**September 12, 2019**

Orleans Heights Development  
 Madison Centre  
 4950 Yonge Street  
 Toronto ON  
 M2N 6K1

**Subject: 3030 St. Joseph Boulevard  
 Residential/Commercial Development Proposal  
 Response to City Questions on Transportation Brief**

LEVEL P2

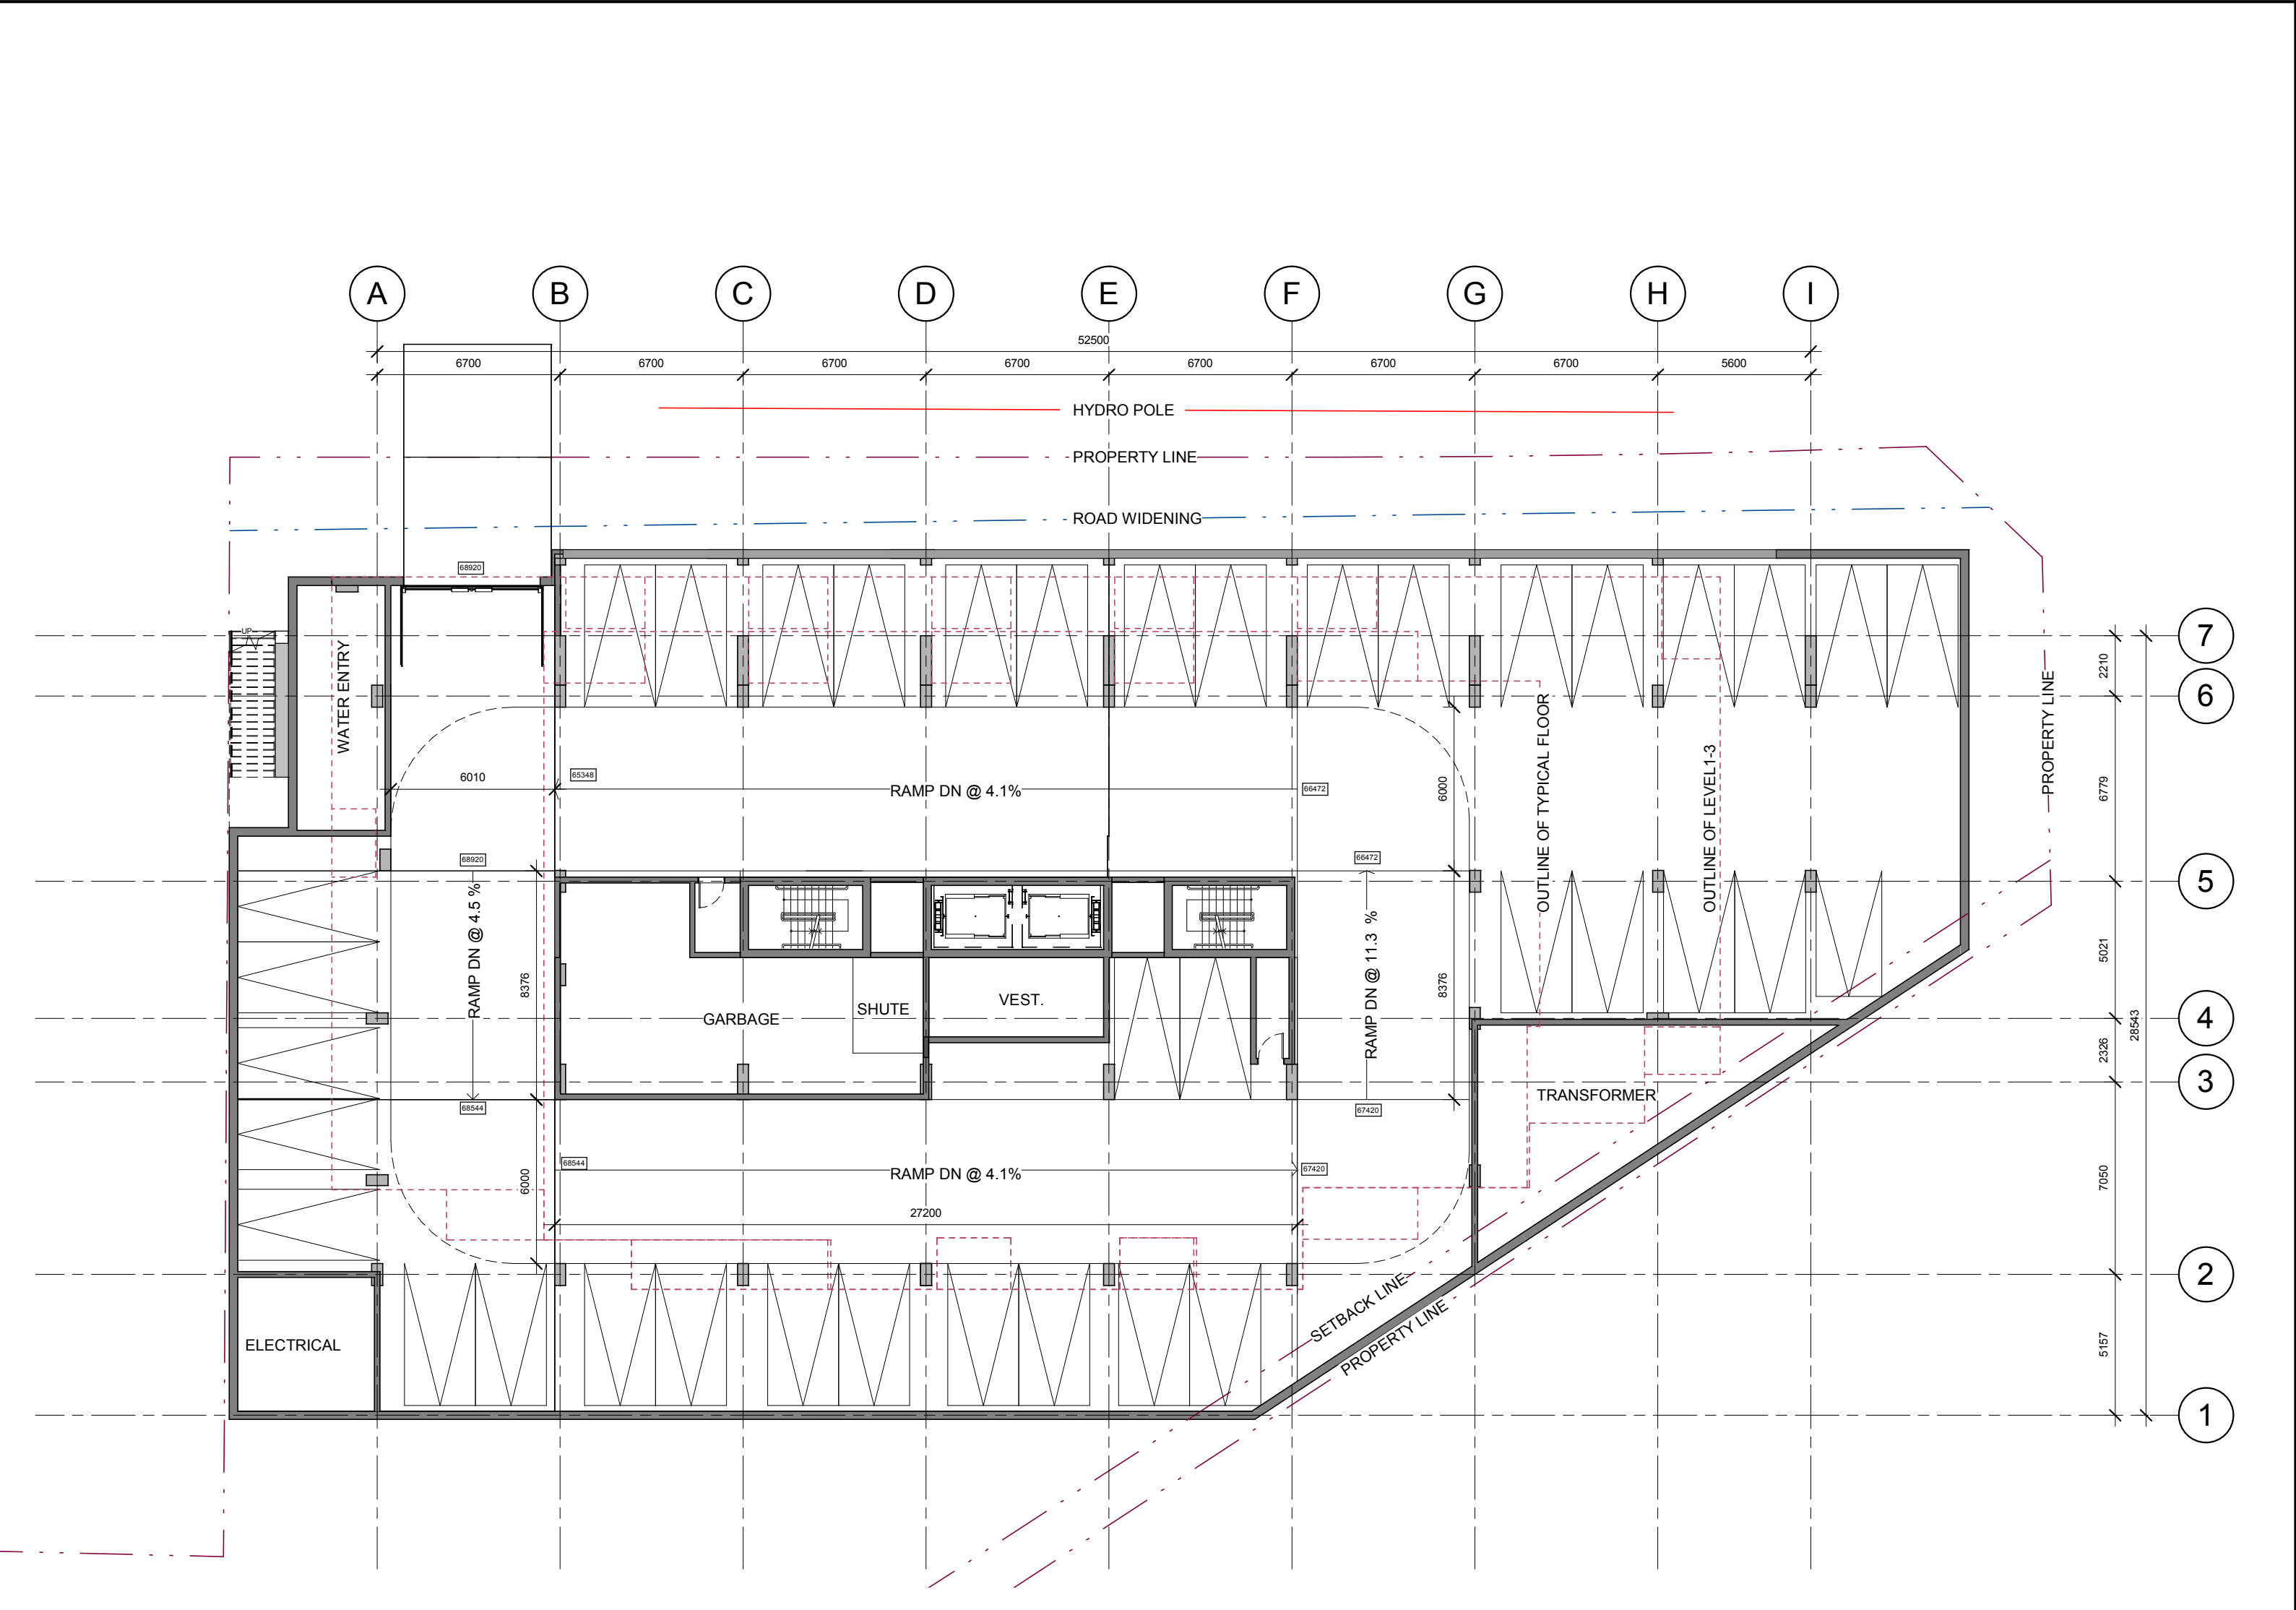
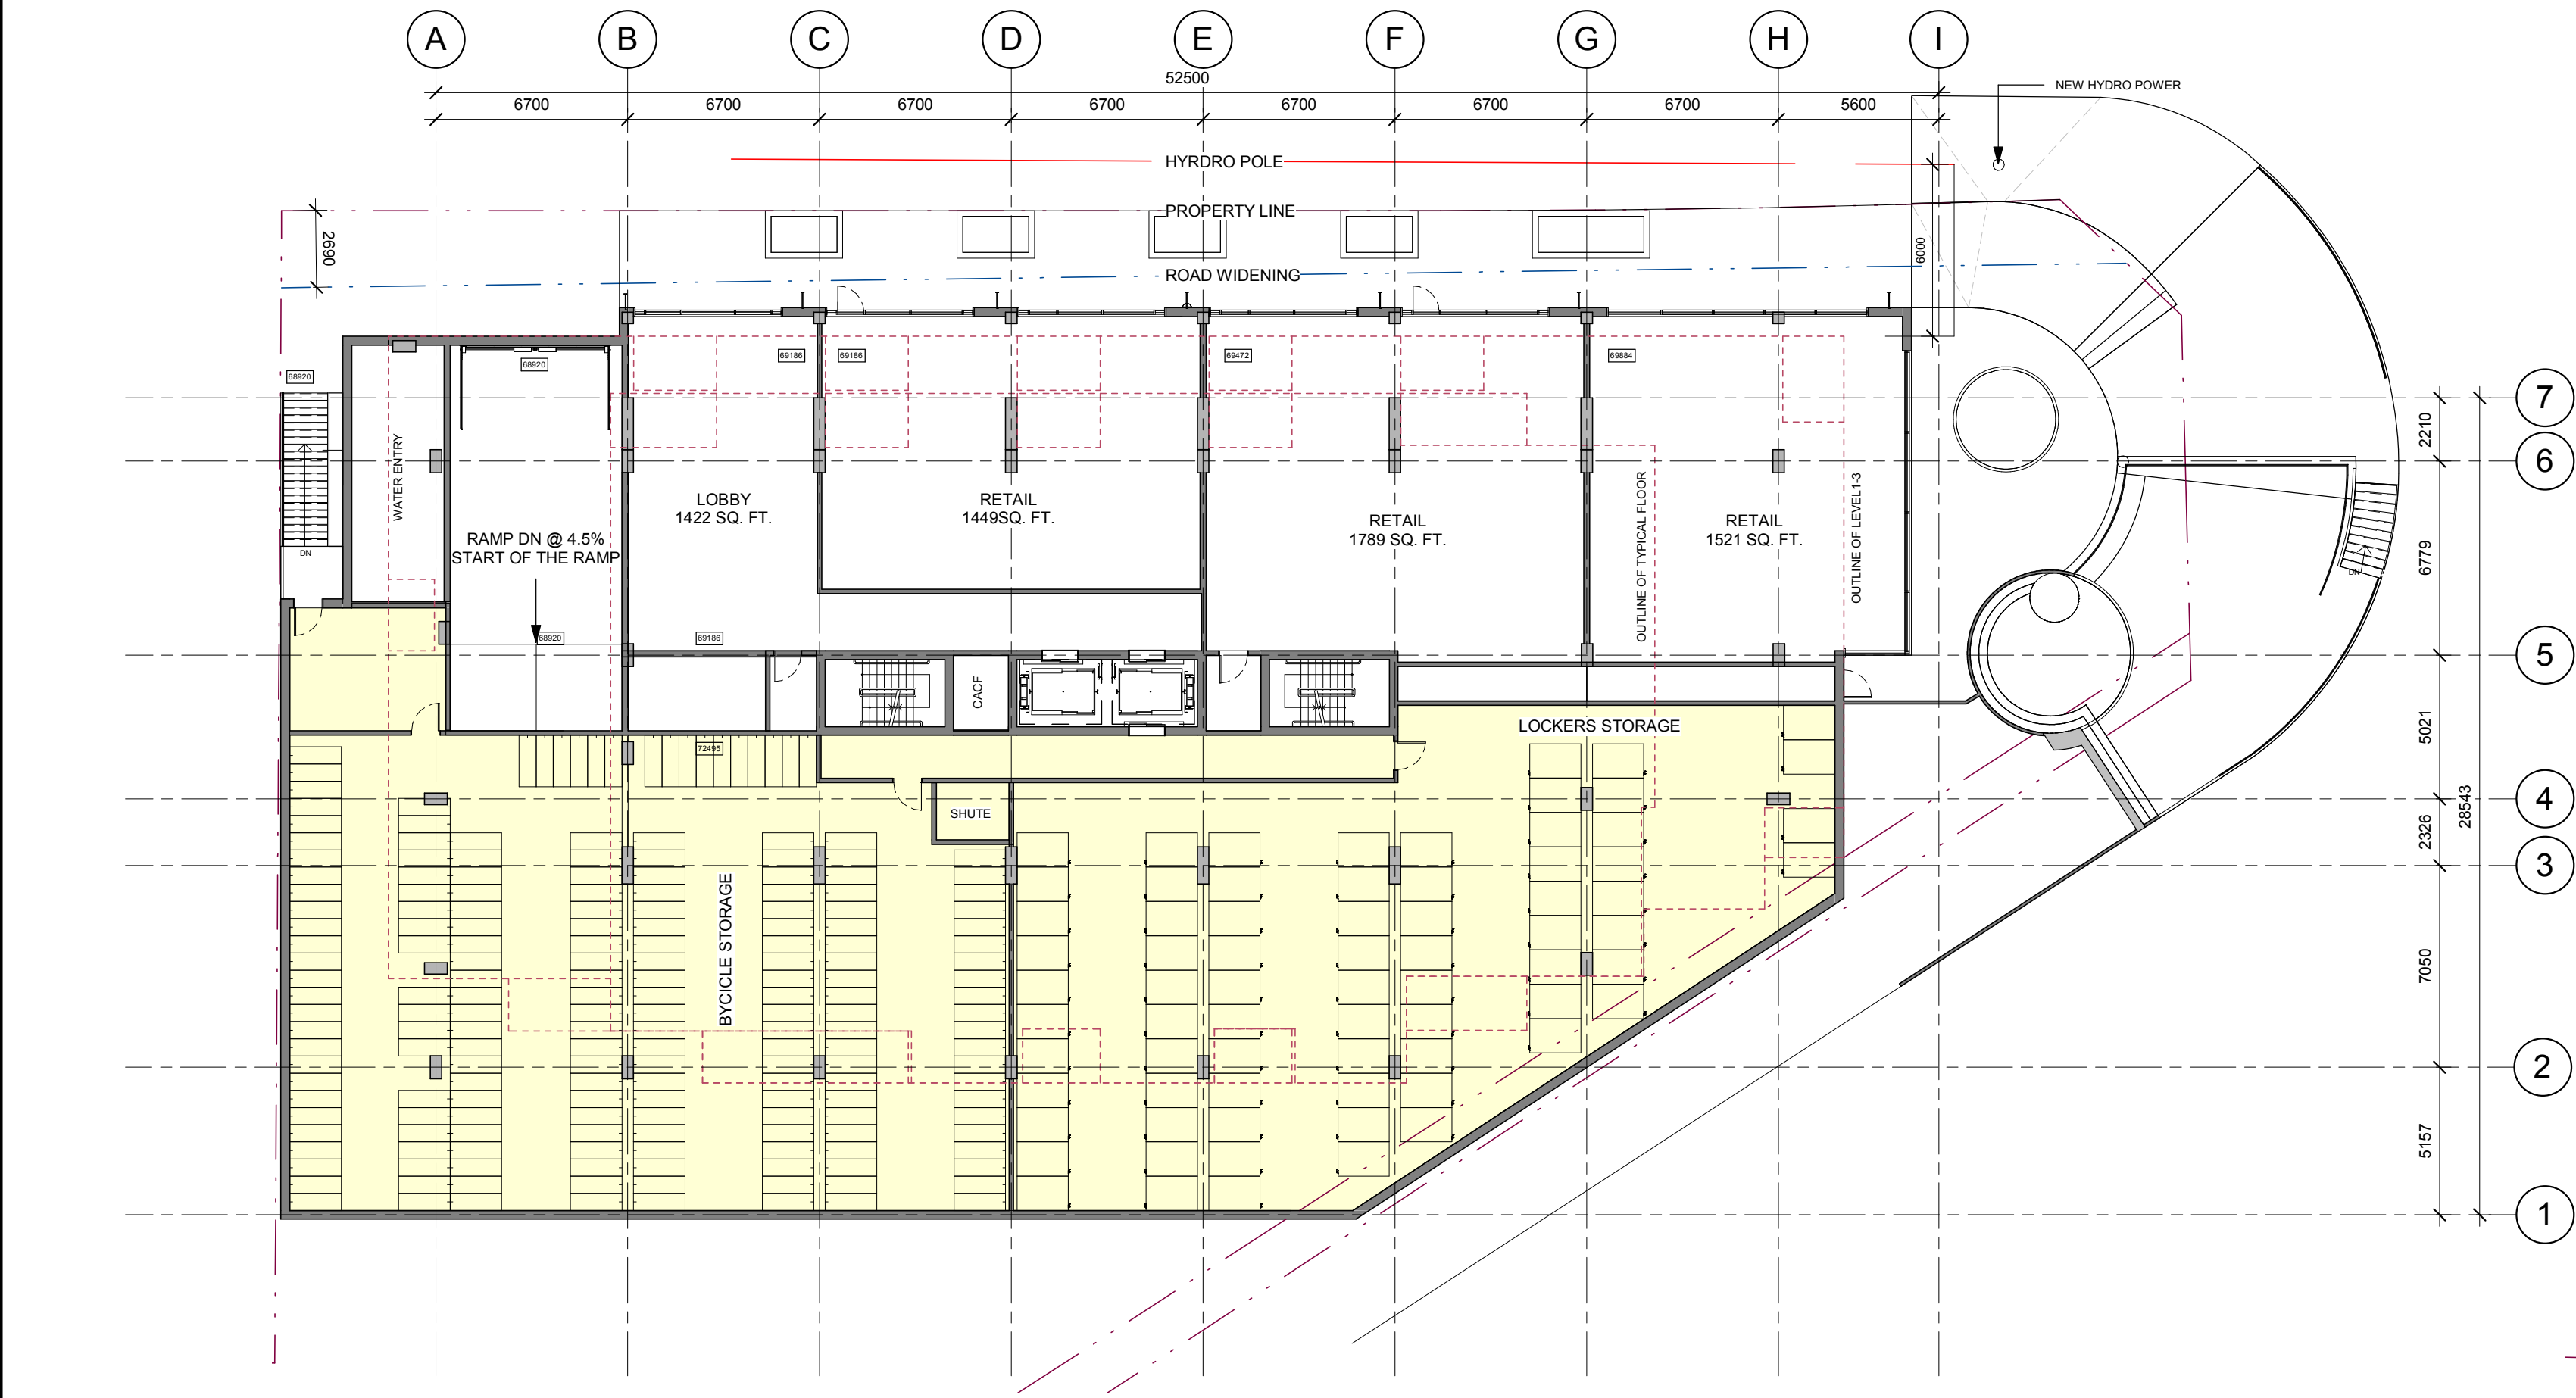
Comment 3: Appropriate measures need to be identified to address the conditions in the garage where two vehicles cannot pass at the same time.

*Response 3: We are advised that the garage's circulation system has been redesigned and that all aisle widths now meet By-Law requirements for two-way traffic flow.*
